CITY OF ALBUQUERQUE

March 3, 2022

**Re: Fiesta Subaru
7100 Lomas Blvd NE
Traffic Circulation Layout
Engineer's Stamp 02-21-2022 (K18-D108A)**

K5 REFUSE ENCLOSURE PLAN
1/8" = 1'-0"

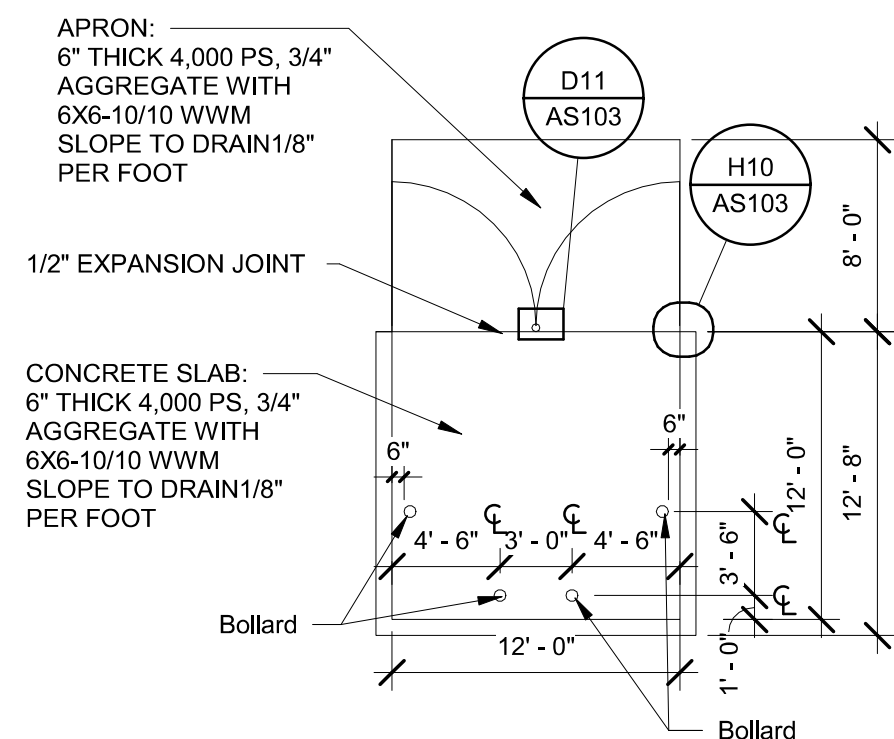
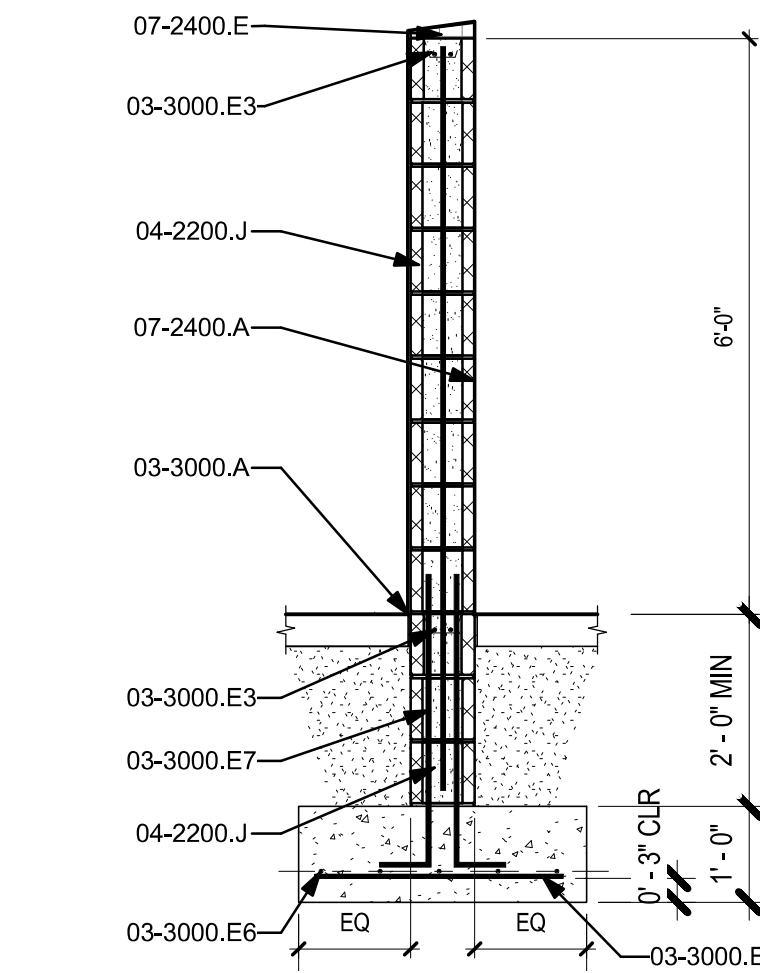
24. Provide a copy of refuse approval.
25. Fire Department: An approval Fire 1 plan needs to be provided.
26. Lomas and Loisiaana: Show the intersection sight distance and add the following note to the plan: "Landscaping and signage will not interfere with clear sight requirements."

A1 SITE PLAN

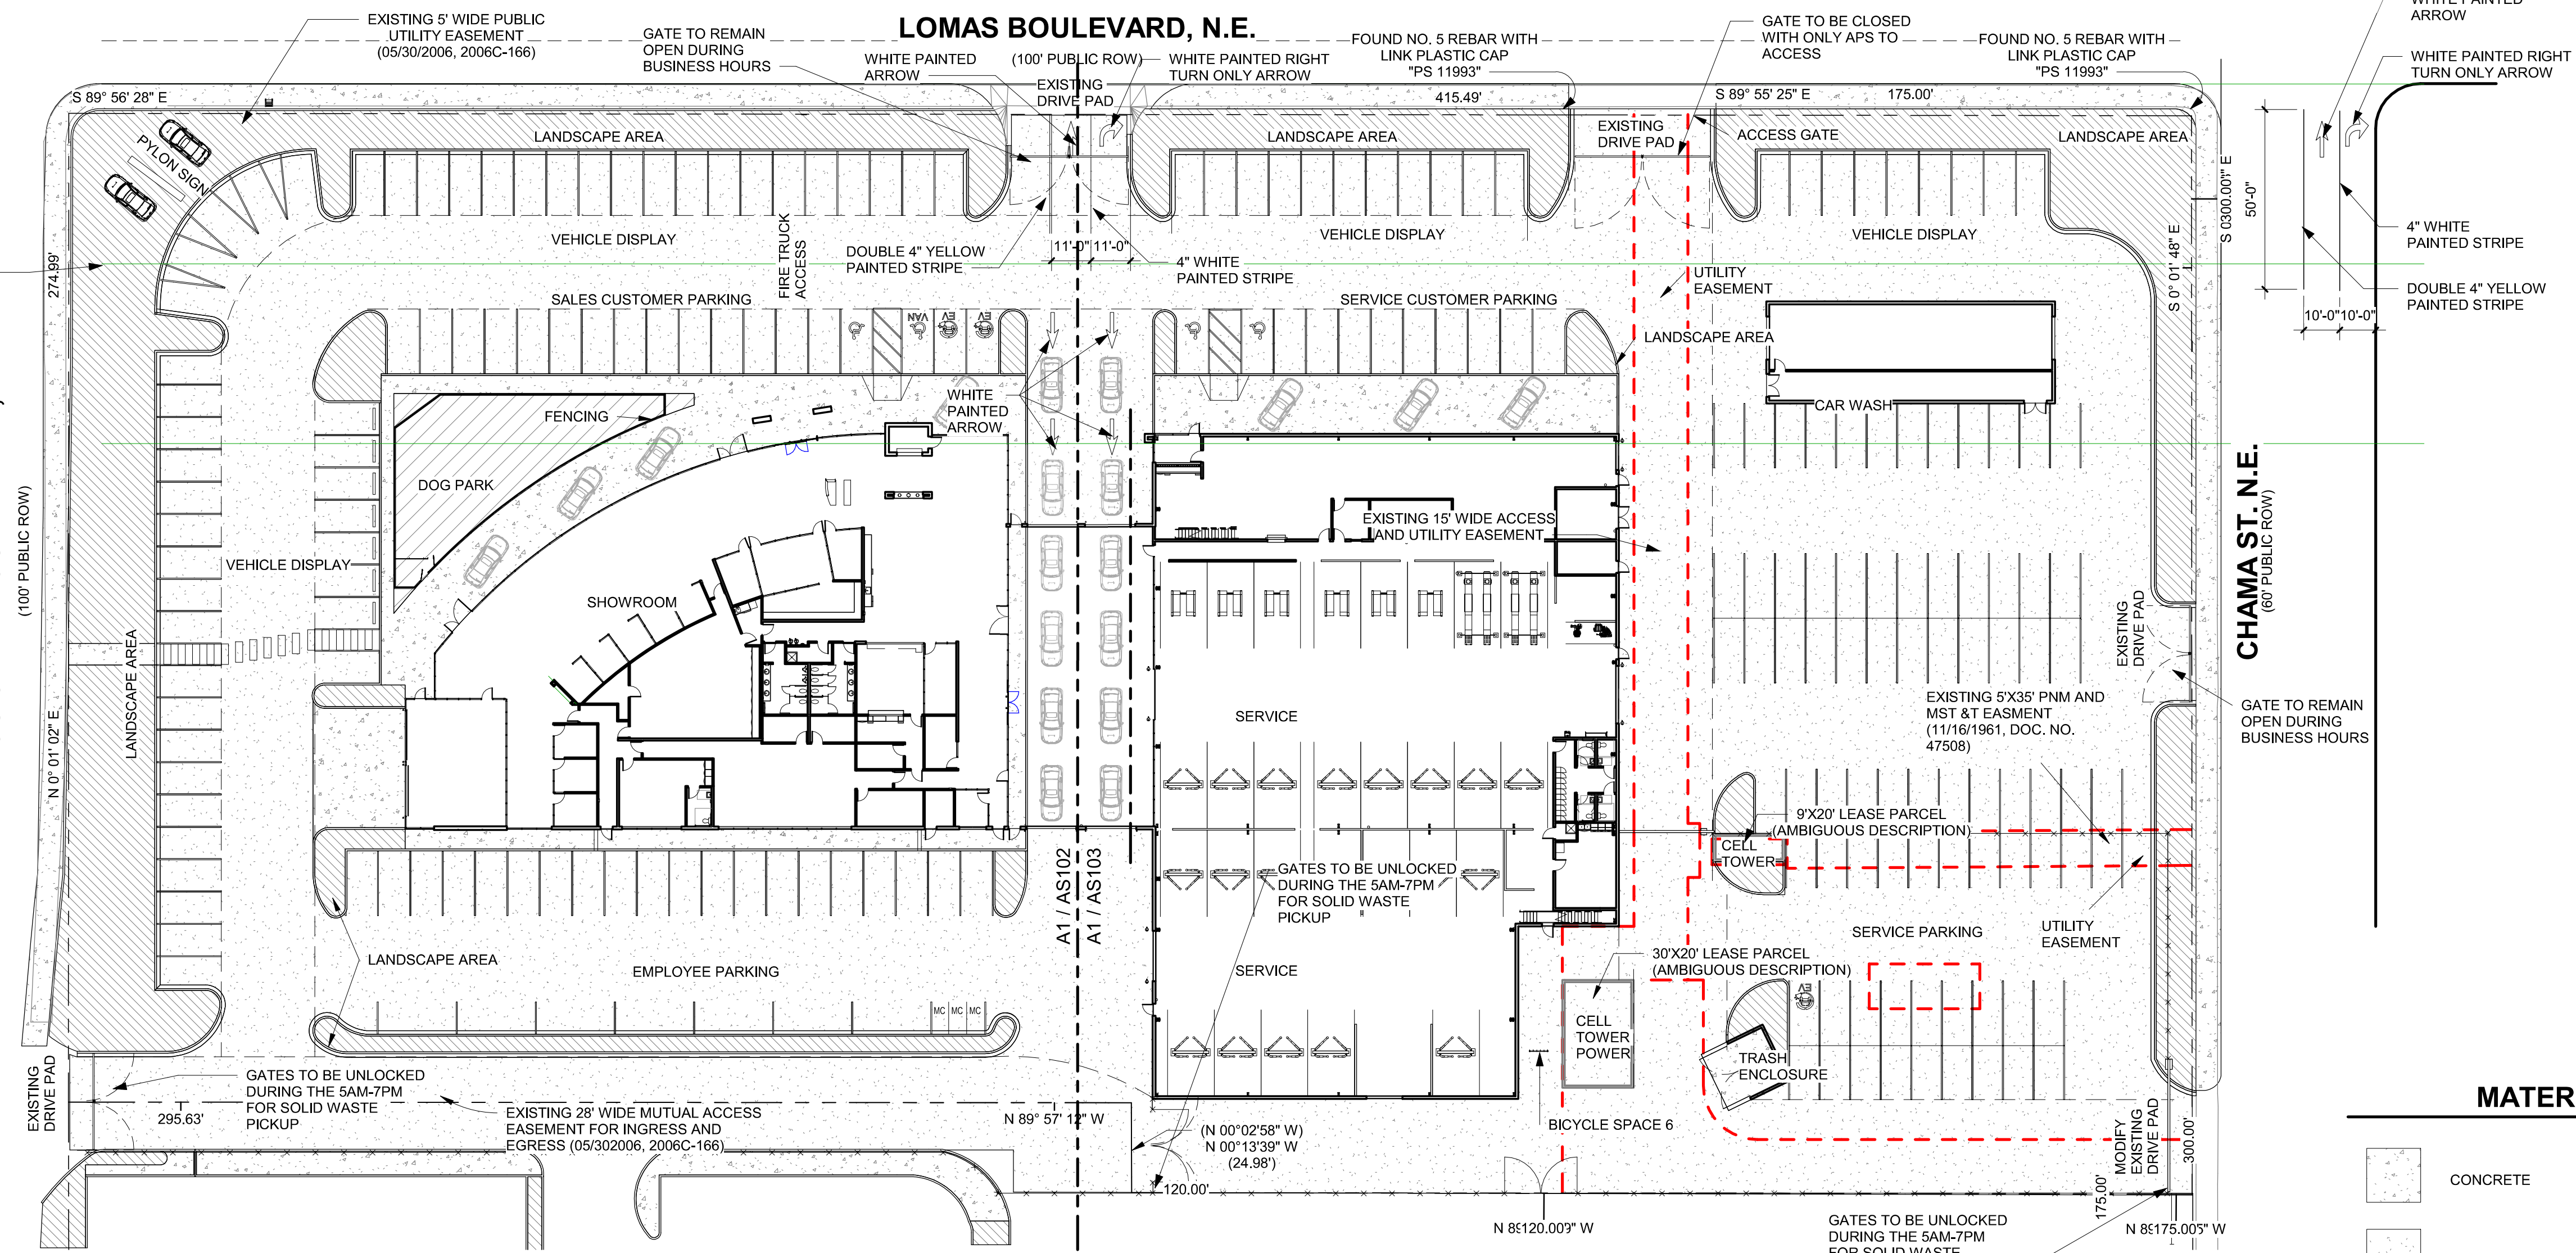
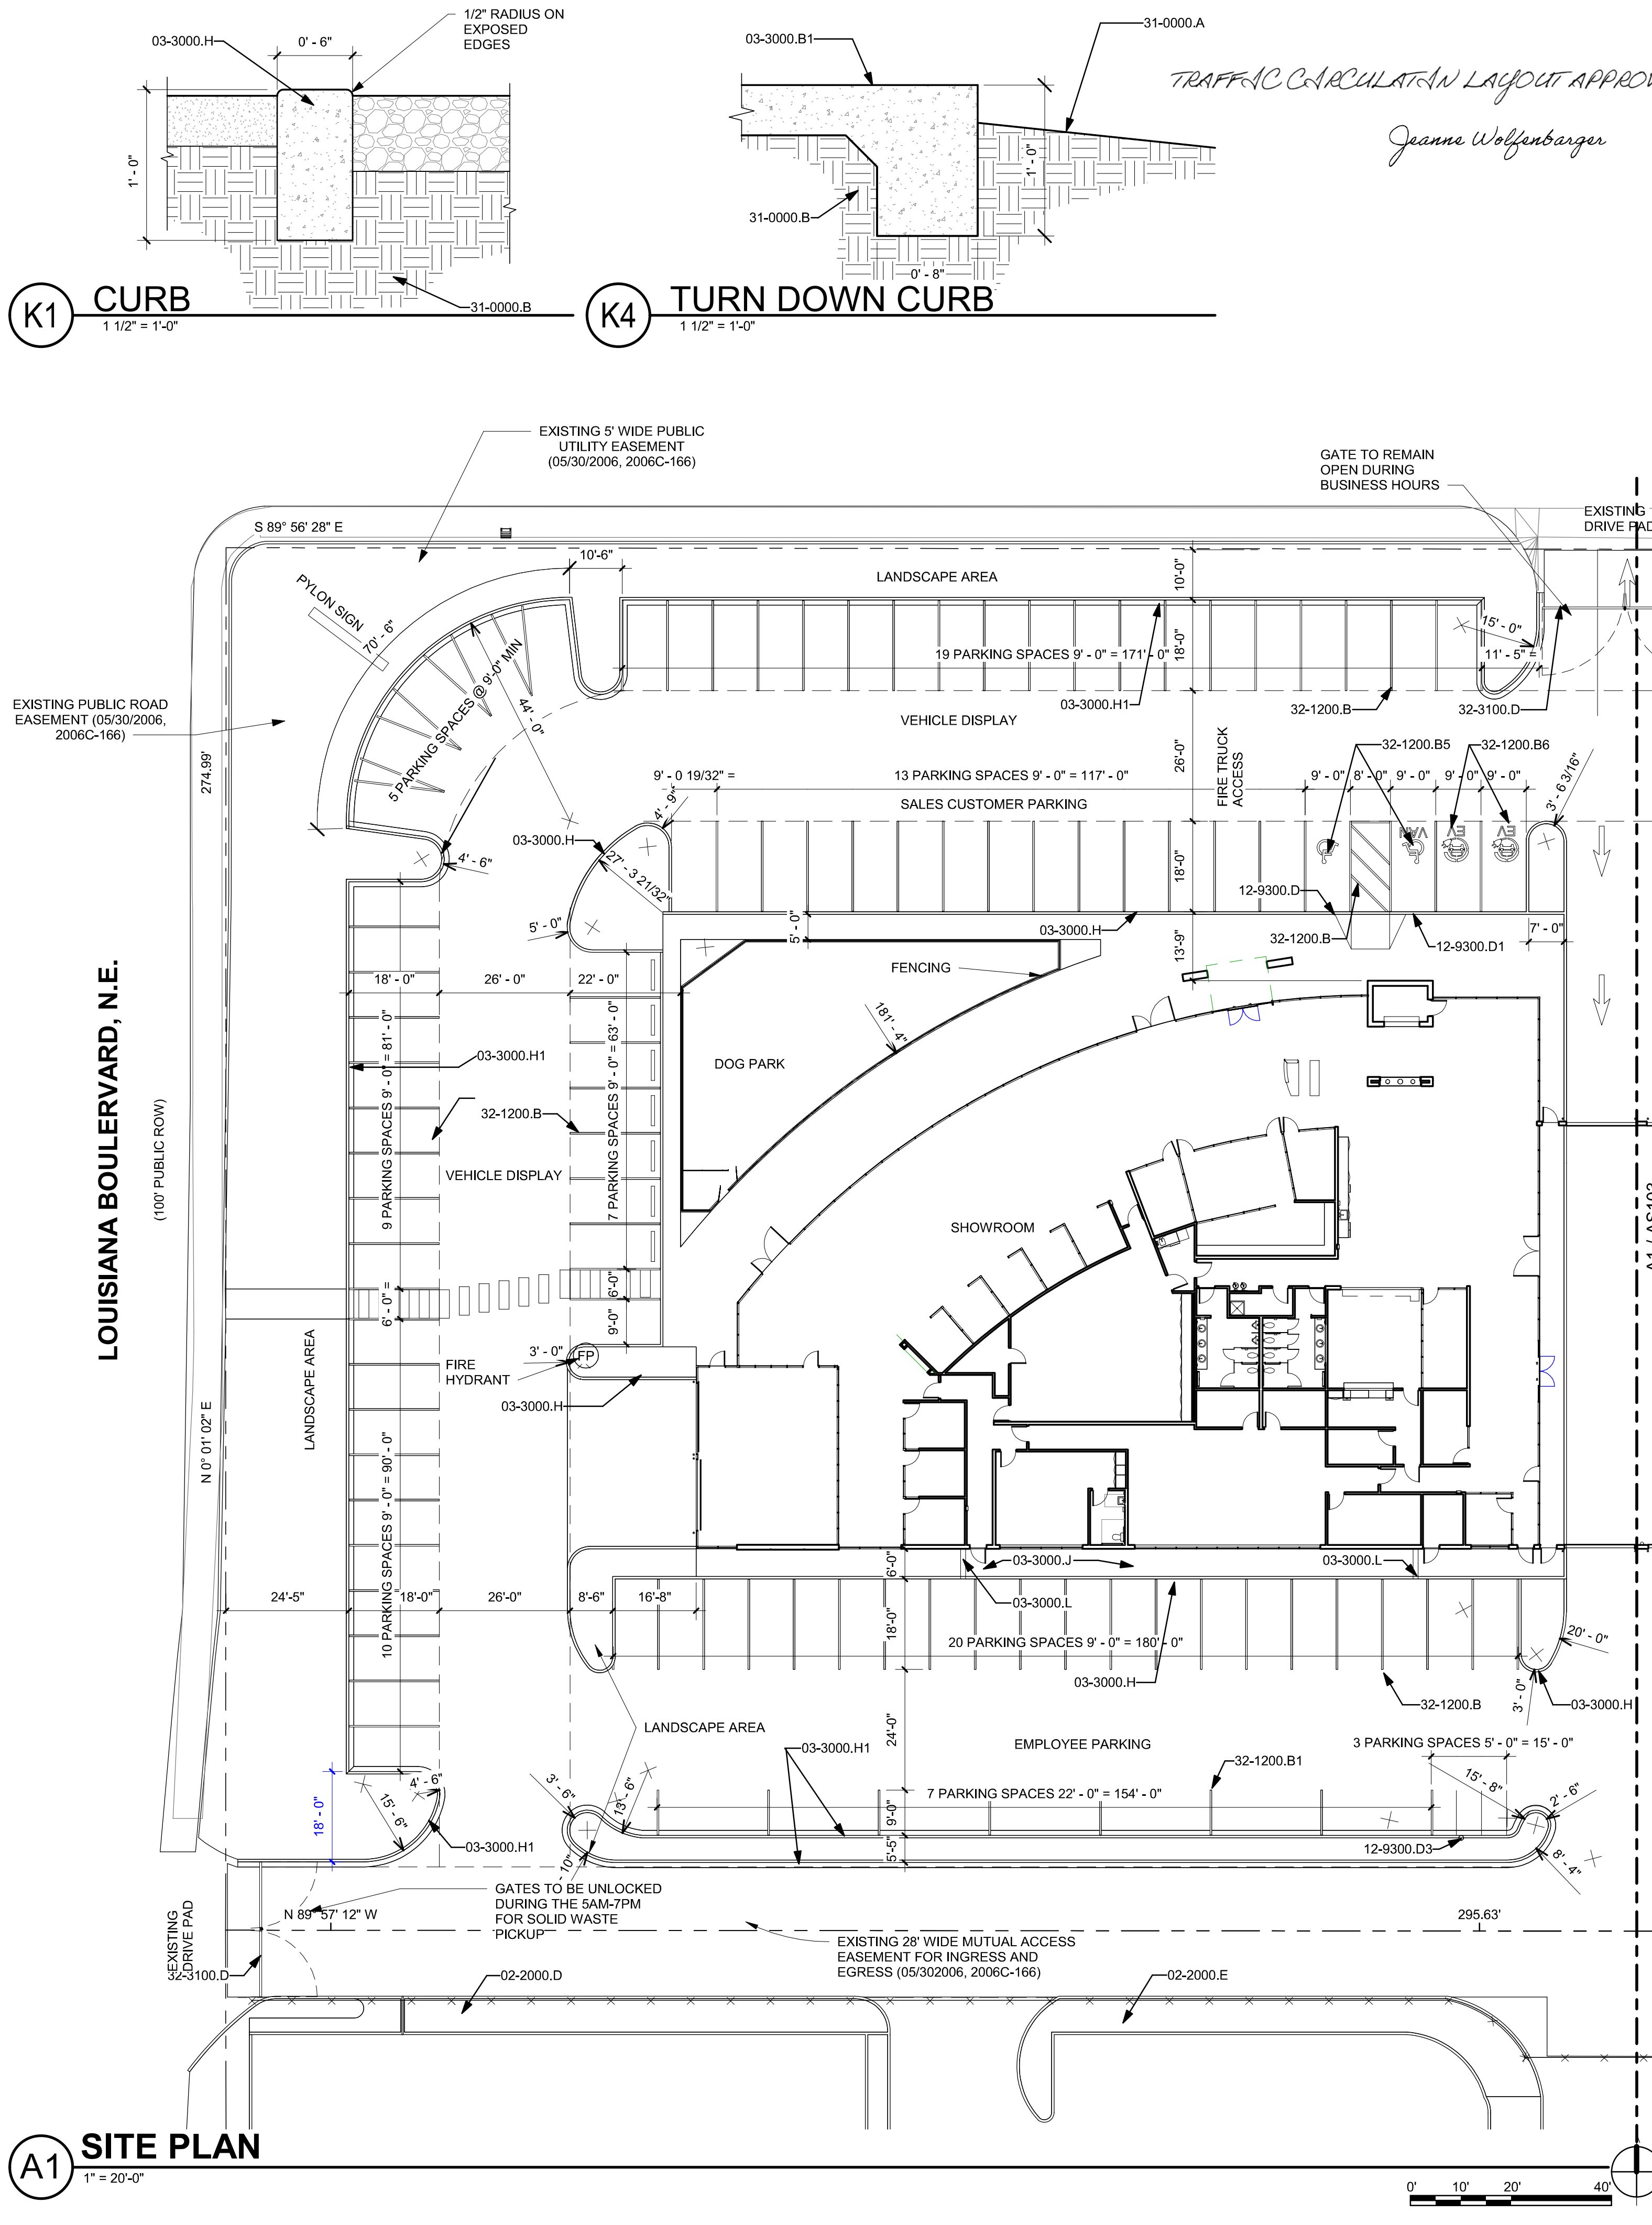
1. Listed are the number of Bicycle parking spaces required by the IDO
Coordinate/discuss with Zoning.
2. **Louisiana/Lomas:**
 - The Minimum Throat depth off an Arterial needs to be comply, please review DPM Design Criteria Table 7.4.81 **Minimum Throat Length.**

3. An ADA ramp will need to be provided at the corner of Louisiana/Lomas. The existing ramp doesn't provide a minimum pathway width of 4 ft to service ADA prior to ramp landing.

4. All existing driveways off Louisiana and Lomas are not ADA accessible. So they will need to be ADA accessible and the design will need to be Curb Return since both roadways are classified as Arterial.

5. Please label the name of side street on the eastern property. **Chama?**
6. Identify the right of way width, medians, curb cuts, and street widths on Chamas st. NE

7. Provide details for all proposed pavement markings.
8. Chamas existing driveway aren't ADA accessible and will need to be addressed.
9. Louisiana's, Lomas's and Chama's main access with proposed gates will need a setback of 20 feet to provide turnout.

10. A sidewalk easement will be needed at the corner of Louisiana/Lomas to encompass the full size of new ramp.
11. Provide turning templates for delivery vehicle.

19. All internal radii's will need to be 15 feet.
20. Per the DPM, a 6 ft. wide ADA accessible pedestrian pathway is required from the public sidewalk to the building entrances. Please clearly show this pathway and provide details.

21. Per DPM, a 6 ft. wide ADA accessible pedestrian pathway is required from the ADA parking stall access aisles to the building entrances. Please clearly show this pathway and provide details.

22. All sidewalks along public streets need widths provided.
23. Parking areas shall have barriers to prevent vehicles from extending over onto pedestrian pathway.

30. Unused curb cuts must be replaced with sidewalk and curb & gutter. A build note must be provided referring to the appropriate City Standard drawing (2430 & 2415A). **Two have been identified but not addressed off Louisiana.**

F10 SIGN-MOTORCYCLE
6" = 1'-0"

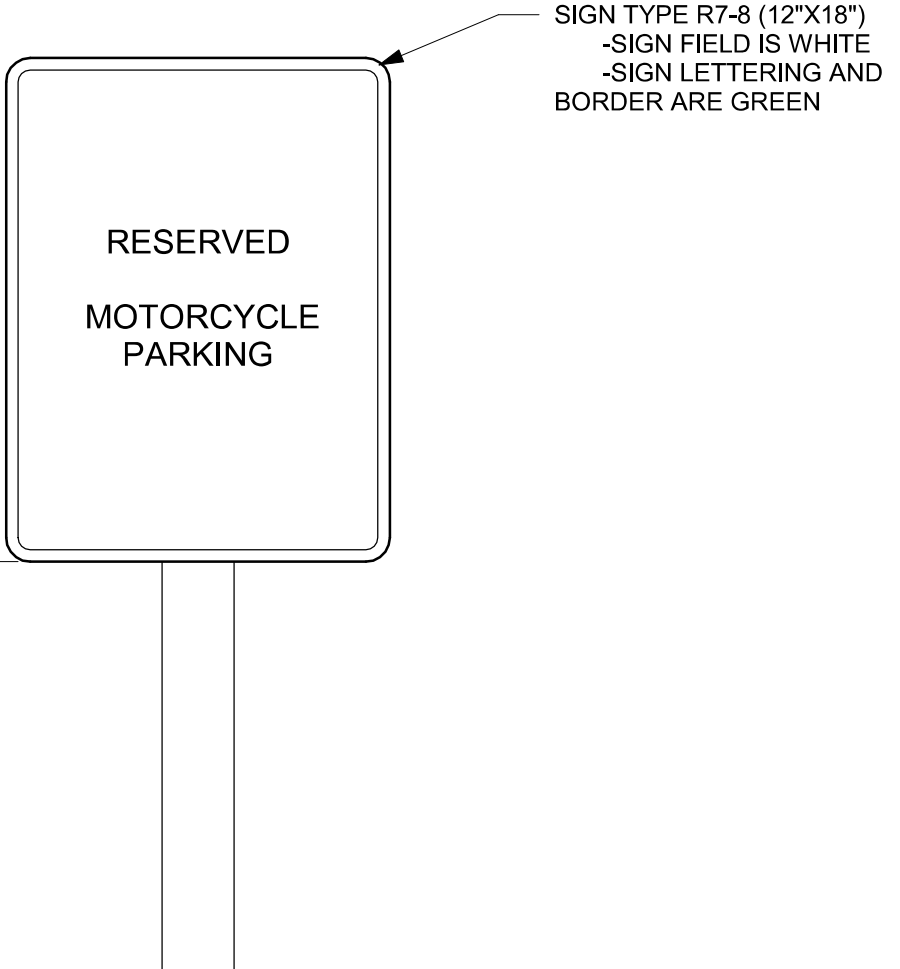
14. **Motorcycle parking spaces:** Label pavement MC.
15. All bicycle racks shall be designed according to the following guidelines:
 - a. The rack shall be a minimum 30 inches tall and 18 inches wide.
